[REDACTED]
Planning applications 3/2023/0844

Planning Application No: 3/2023/0844.
Resubmission of application: 3/2023/0058.
Re: 5 Whalley Road, Read.

*Retention of unauthorised 1500mm timber fence on roof of rear garage 1m in
From neighbouring boundary on one side.*

REAR ELEVATION - 1:100 at A3

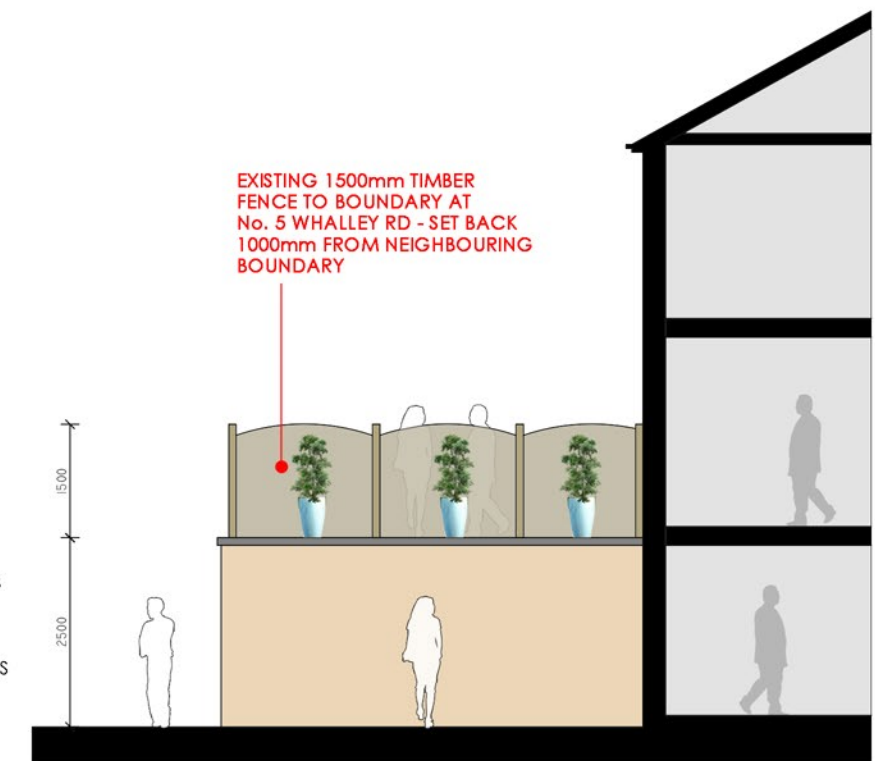
The applicants previous rejected application 3/2023/0058 was appealed and went to the Inspectorate* who clearly rejected the appeal on No 3 right for Light along with the dismissal of the proposed plans submitted by No 5 due to discrepancies, this is now being repeated with incorrect and misleading plans again being submitted and show incorrect height of unauthorised fence in relation to

[REDACTED] no showing of a rear window at No5 overlooking the garage, any movement of the unauthorised fence back would then have a solid fence sited across the middle of the unshown window that would hardly give any further privacy and would look stupid with the window bordering each side of a fence.

I have been shown the Rear Elevation Plans for the above and note that they
are misleading and do not reflect a true copy of the existing Fencing and Height.

I have been shown the Rear Elevation Plans for the above and note that they
are misleading and do not reflect a true copy of the existing Fencing and Height.

I have been shown the Rear Elevation Plans for the above and note that they
are misleading and do not reflect a true copy of the existing Fencing and Height.

SUN PATH PLAN - 1:500 at A3

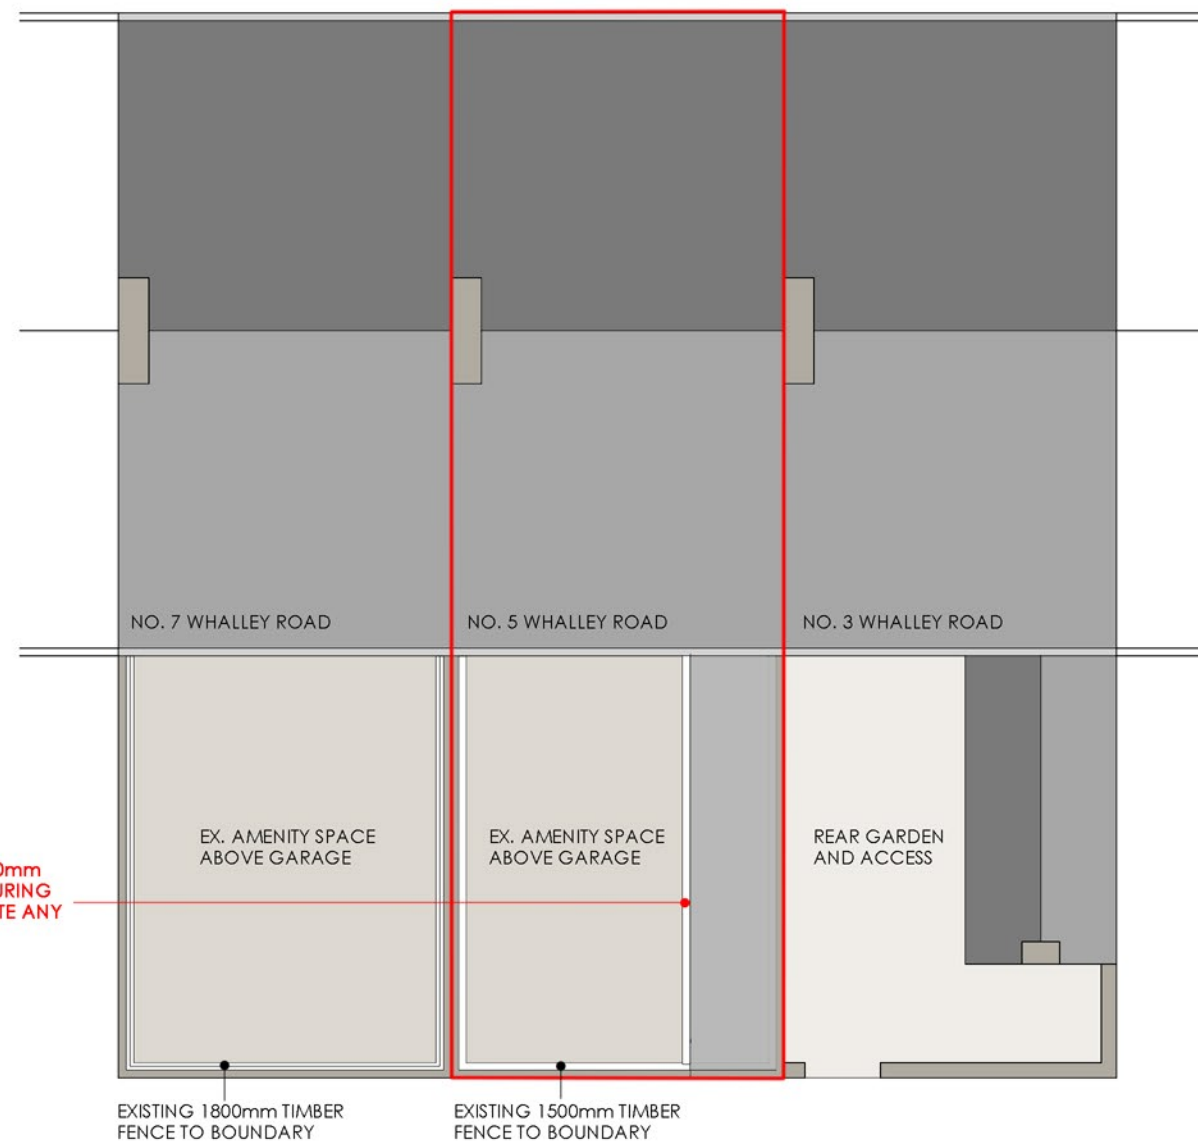
The properties are south facing and have a clear rotation of the sun across the back and since the unauthorised fence was erected a further third of light was lost (half as much again to the garage height), by now suggesting the unauthorised solid fence is moved back 1mtr is giving little back as the sun sets to this west side and amounts to most of the available day light.
